Application No: EP/15/25/HH  
Site Address: 38 Roundstone Drive East Preston BN16 1EP  
Description of works: Part single, part two storey rear extension with raised deck and reposition front door.

Thank you for your internet representation made on 27th March 2025 which has been recorded as no objection with the comments as follows:

West elevation scale 1:100

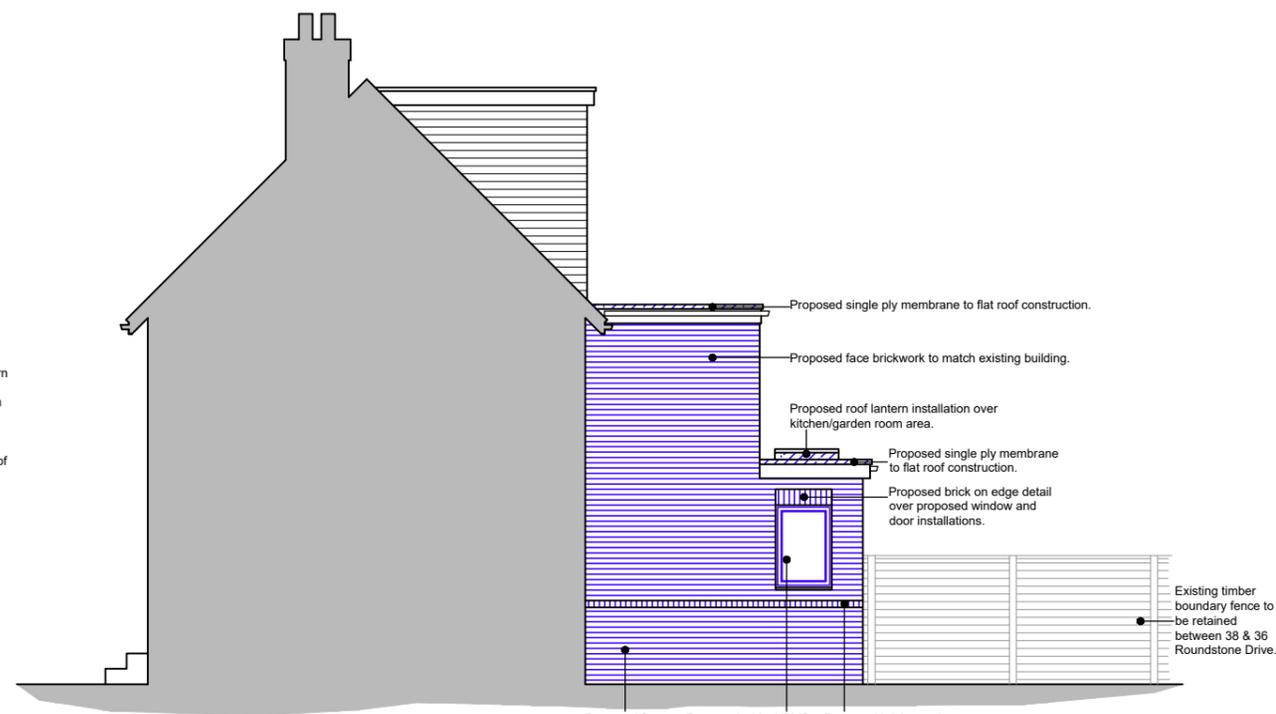
However, it did ask ADC to consider applying a Condition the ground-floor window proposed for the west elevation be of obscured glass in perpetuity to prevent overlooking the neighbouring property.
